**Consultation Response from KC,
Highways Development Management****2023/93031 Wappy Springs Inn, Lindley Moor Road, Lindley Moor, Huddersfield, HD3 3TD****Erection of mixed industrial development (Use Classes E(g)(i, ii, iii), B2 and B8); including demolition of existing structures, new yard, parking, landscaping, drainage features and ancillary structures****Date Responded: 15/02/2024****Responding Officer: Ryan Kinder****Responding Ref: K2-13/7**

RECOMMENDATION: Further information is required regarding the following issues, which are detailed in the main body of the report:

Scale	Size	Date	Drawn	Checked
1:500	A3	DEC'22	MH	.
Status	<b>PLANNING</b>			
KPP Job No <b>2278</b>	Rev <b>A</b>	Number <b>2002</b>

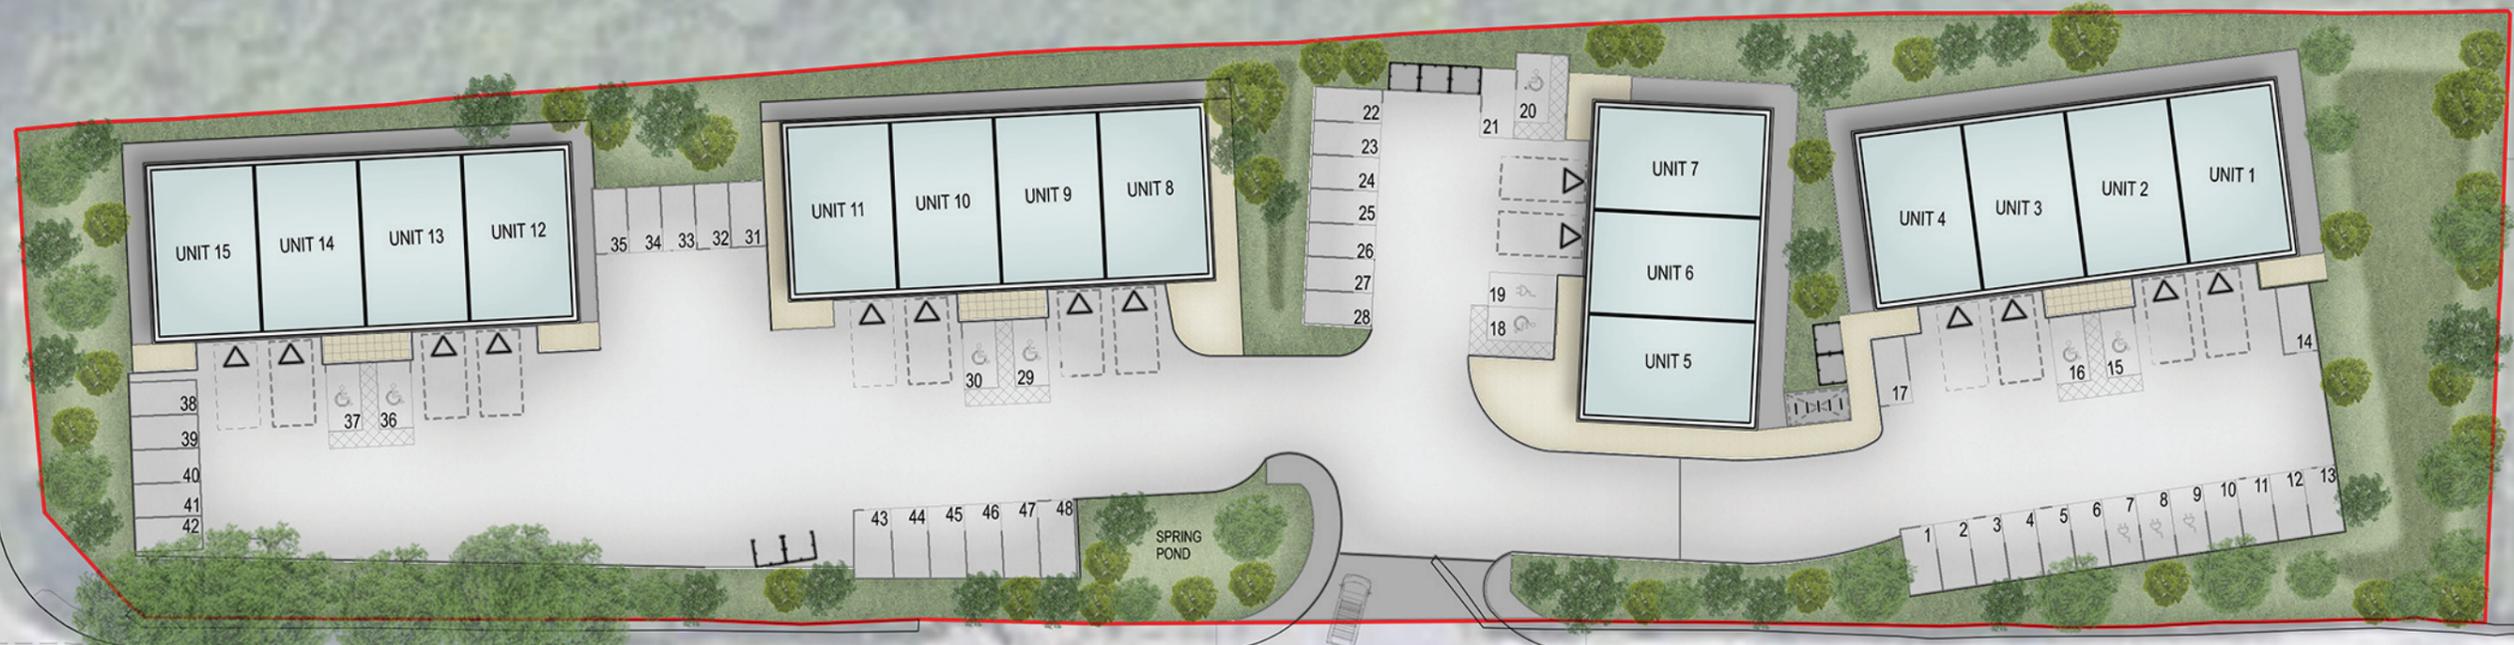
It is proposed to access the site via one singular point of access off the A642 Lindley Moor Road, given the posted speed limit of 40 mph and observed driven speeds along Lindley Moor Road it is imperative that the junction and deceleration lane into the proposed development are designed to DMRB standards in accordance with CD123, in addition given the site will facilitate a large quantity of HGV's the proposed site access should have 10m corner radii. Confirmation that this has been carried out should be clarified and detailed on plans accordingly. In addition the current layout may not extend far enough back into the site to avoid conflicts between long vehicles turning in and other traffic moving in the site (crossing east-west / vice versa). This could lead to long vehicle's stopping early, and their trailers overhanging the carriageway, with obvious consequences. Problems could also occur if multiple smaller vehicles arrived at the same time whilst others were exiting. It would be better if the units were located along the front of the site facing north, with the access carried towards the rear of the site, before any 'side-road' junctions were taken from it.

There is no splay to prevent trailer overrun of the footway by longer vehicles turning left out, the alternative being them swinging out and overrunning the oncoming central right turn lane, which would be unsafe. To summarise it is therefore recommended that the site be reconfigured with the units fronting Lindley Moor Road, with parking and access road to the rear.

The proposed parking provision needs to be carefully considered with the correct provision and sizing of parking bays, enough disabled provision swept paths of vehicles manoeuvring in and out of bays where space appears tight in some instances.

SWEPT PATH ANALYSIS

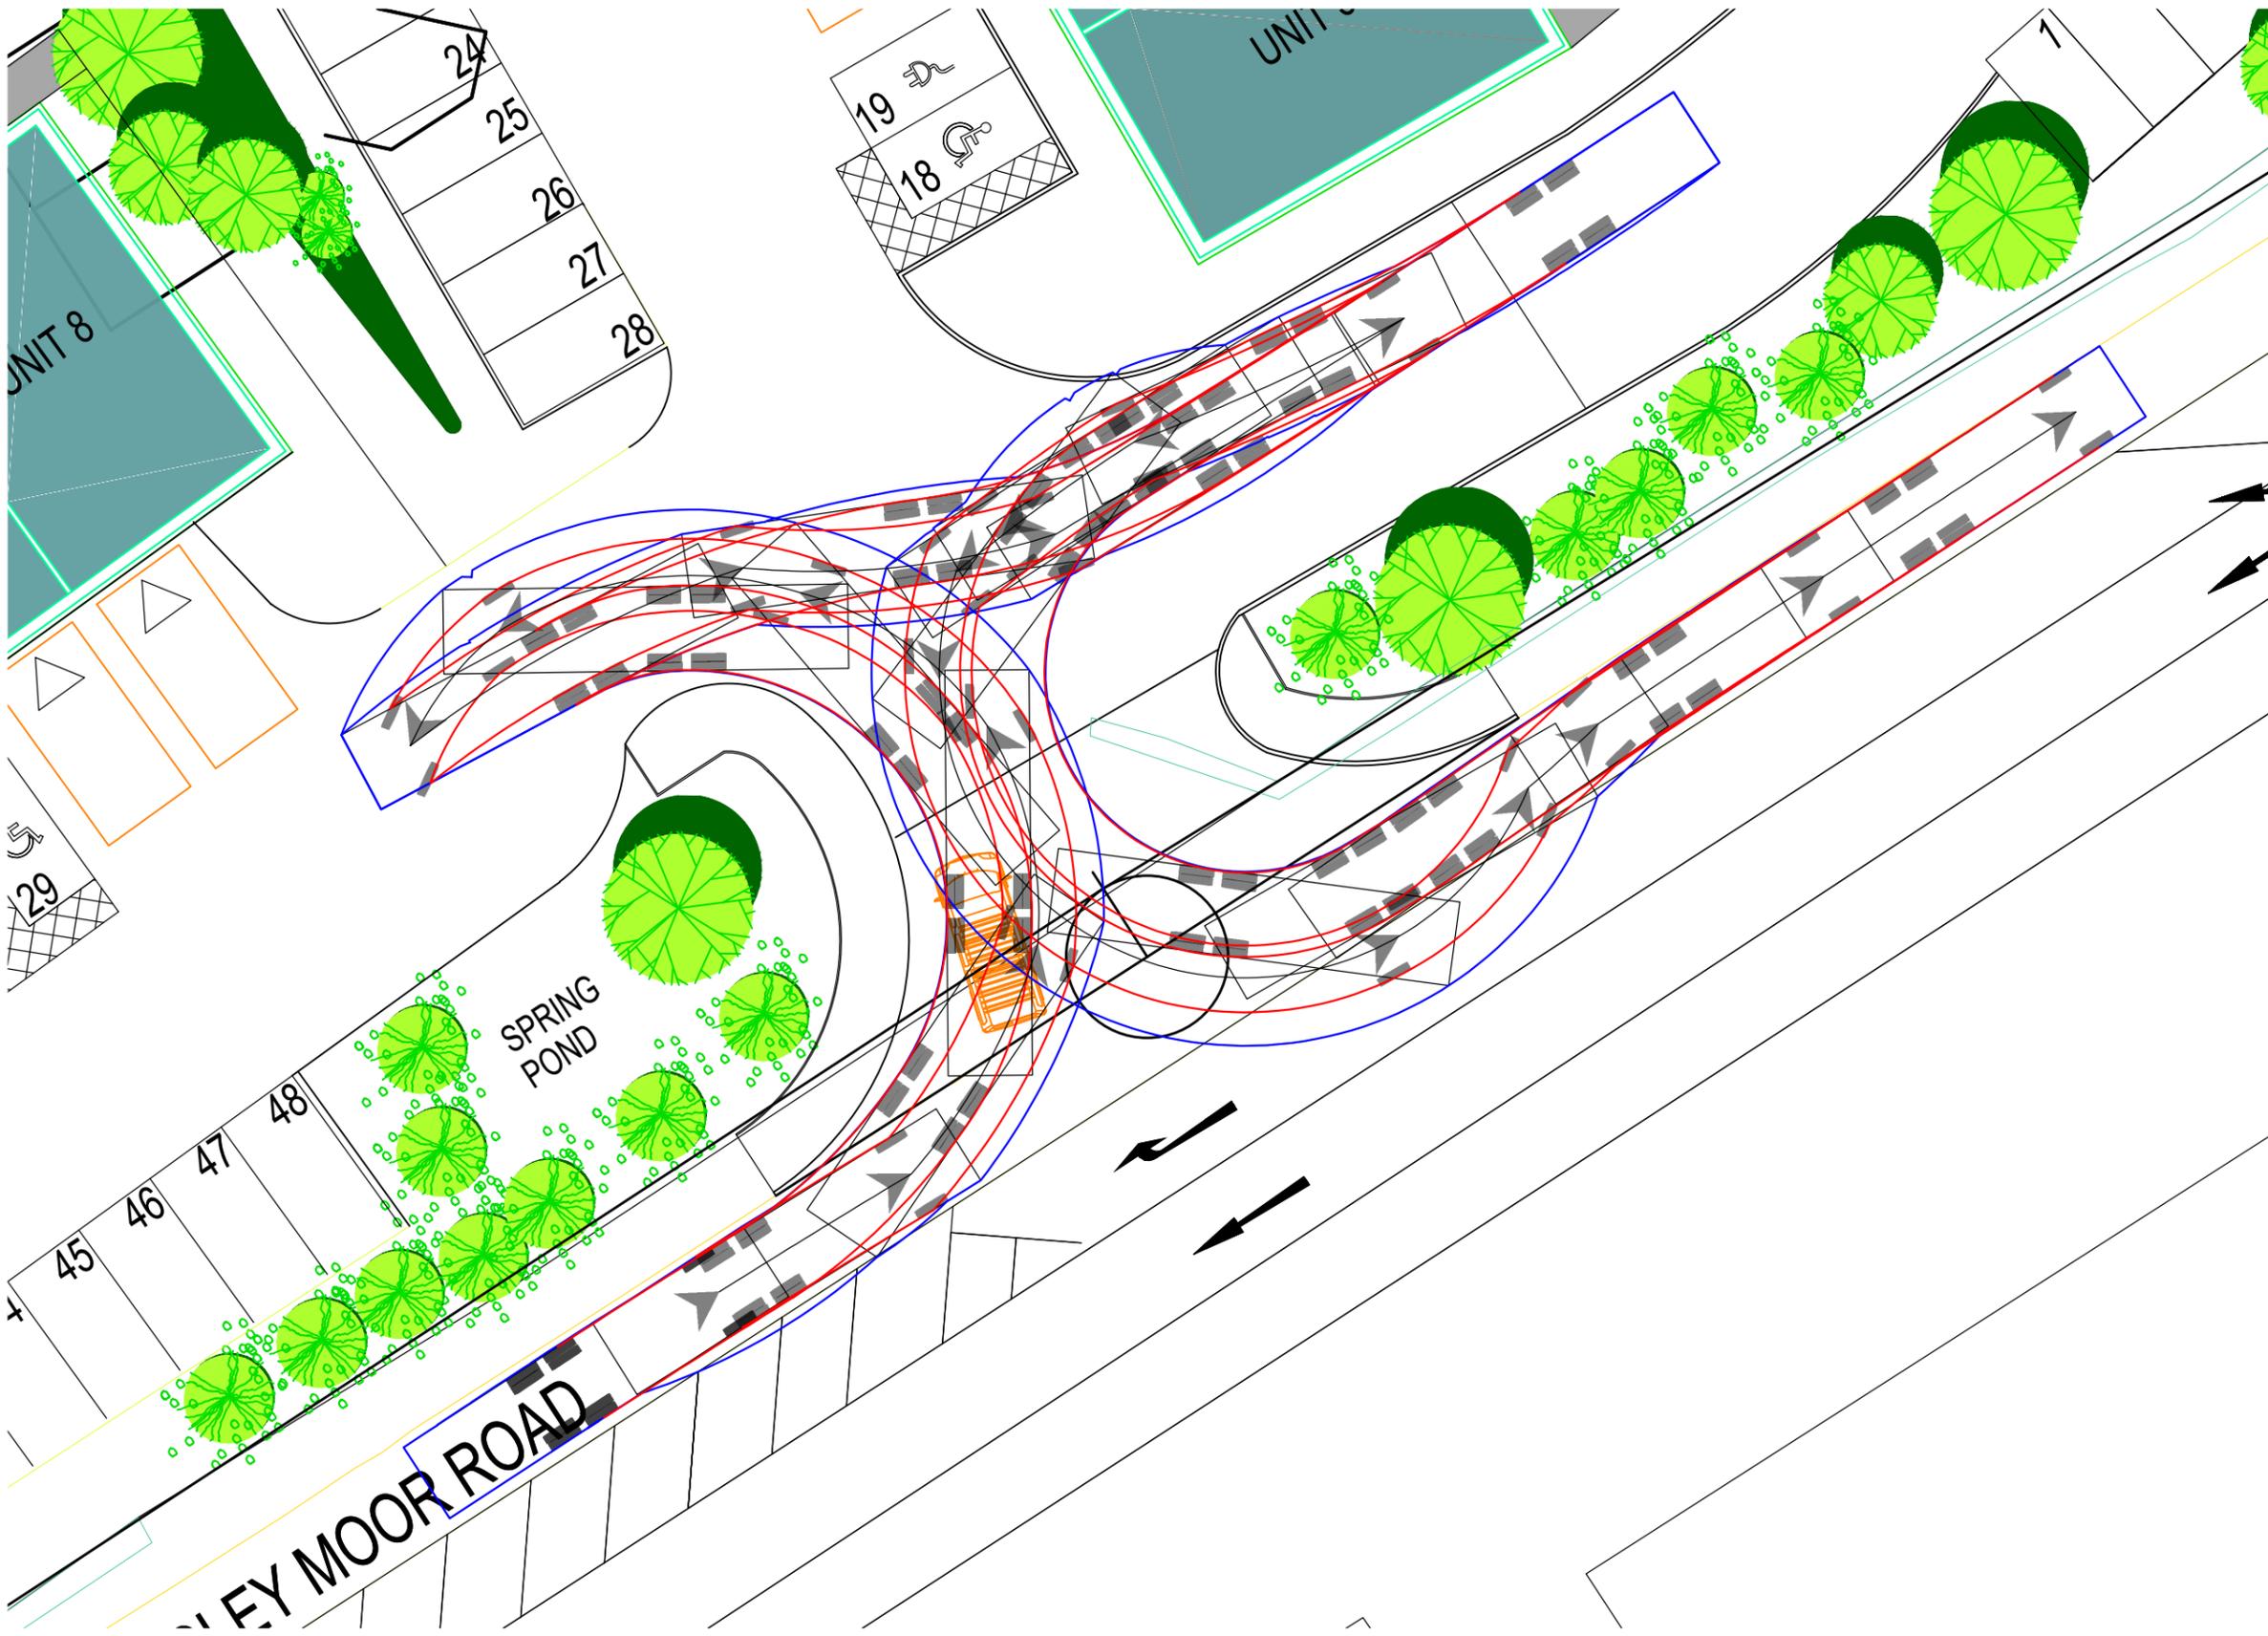
Various amendments to the site layout and parking provision are required to accommodate HGV movements to and from the site safely, with amended plans including construction details, vertical alignment/gradient details, junction/forward visibility details and additional Swept Path Analysis (SPA) etc. Once agreed in principle, the layout must be subject to a Stage 1 Road Safety Audit (RSA Brief and Team to be agreed with HDM).
